Your Ref: OWPC13235
Our Ref: FP/35/17/HH 08-02-2017
Please ask for:
Richard Temple

Relocation of existing boundary wall & timber fence to provide access to side garden
from rear garden.

14 Bridger Close Felpham

*OBJECTION TO PLANNING APPLICATION - FP/35/17/HH - 14 Bridger Close, Felpham,
West Sussex*

ELEVATION LOOKING EAST
(AS PROPOSED)

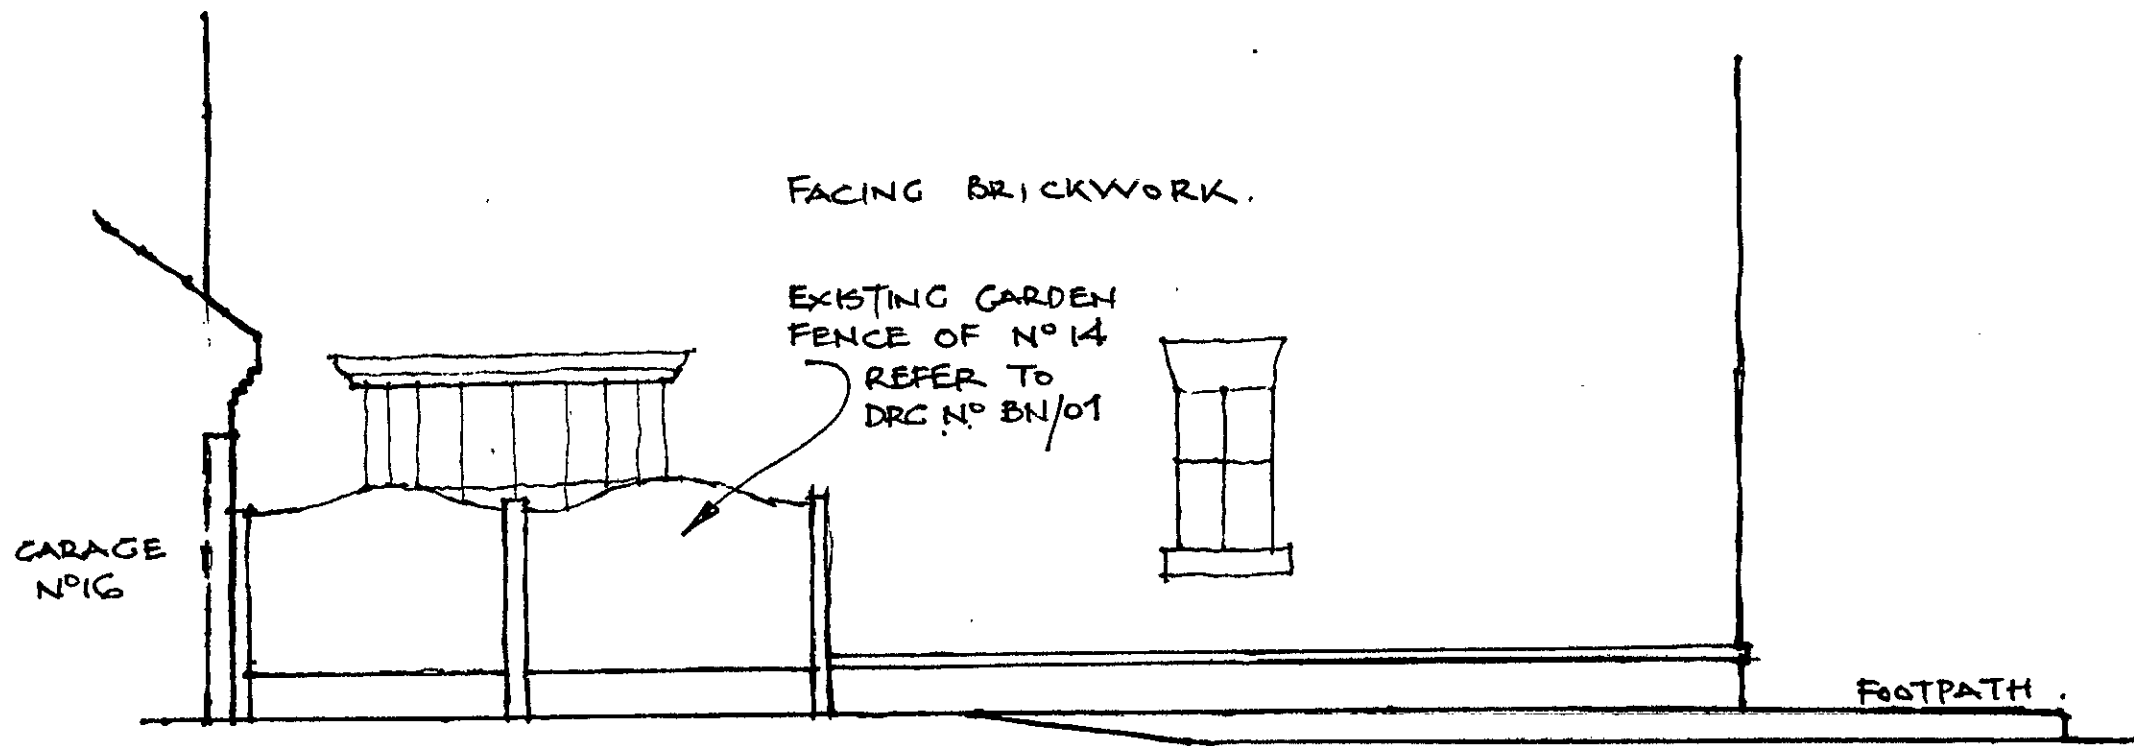
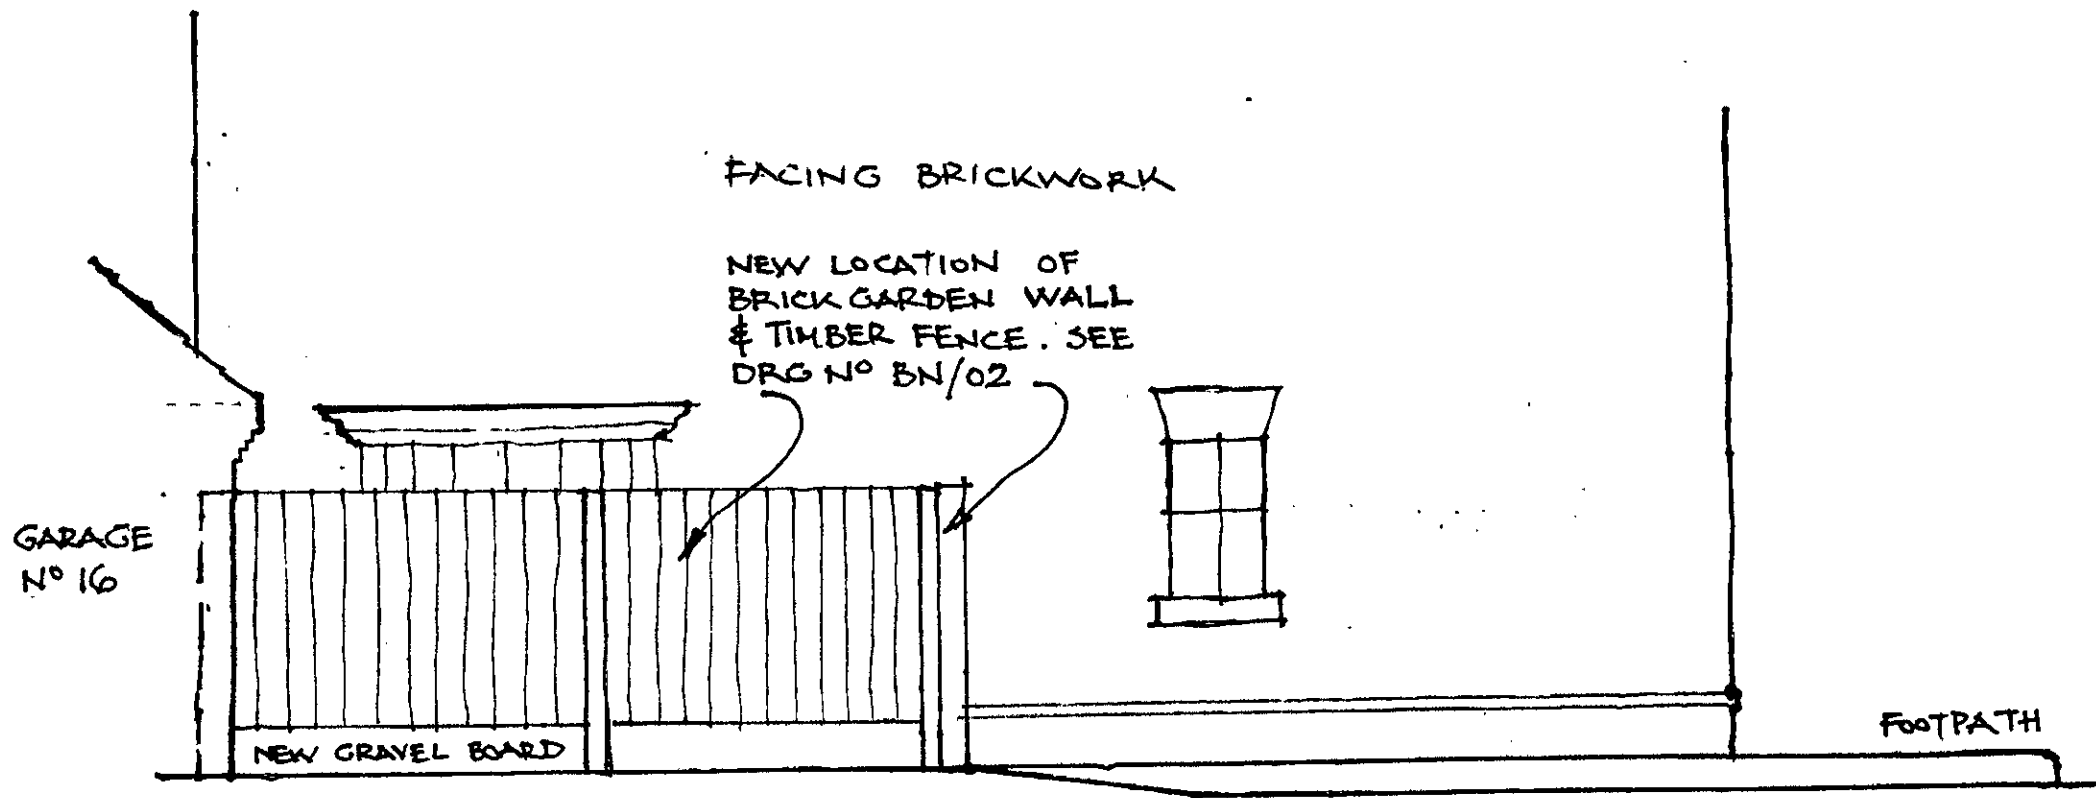
*The applicant has without consent or planning permission to which we are seeking legal
advice at present put a 2 metre approximately sky blue/green fence to the side of the
property to which they refer to as existing which is not anywhere near within keeping with
the said estate. It is unsightly and distasteful in colour to which we have to look out onto
from our Kitchen, Bedroom and Dining Room window as our house front is adjacent the
their side garden.*

The brick wall to which the applicant is intending to take down is attached to our garage wall and we give no permission take down the wall.

Within saying this we would like to put forward a proposal to the planning department and the applicant that we are willing as a gesture of goodwill to enable a way forward and only if permission is granted by David Wilson that a redesign of materials with 225mms solid brick wall to keep in keeping with the rest of the development and so that there is no maintenance needed as close boarded fence will break down overtime and the applicant has shown the close boarding would need to be maintained on our property which is not granted. This would be also more cosmetically pleasing to our outlook and to the other surrounding properties.
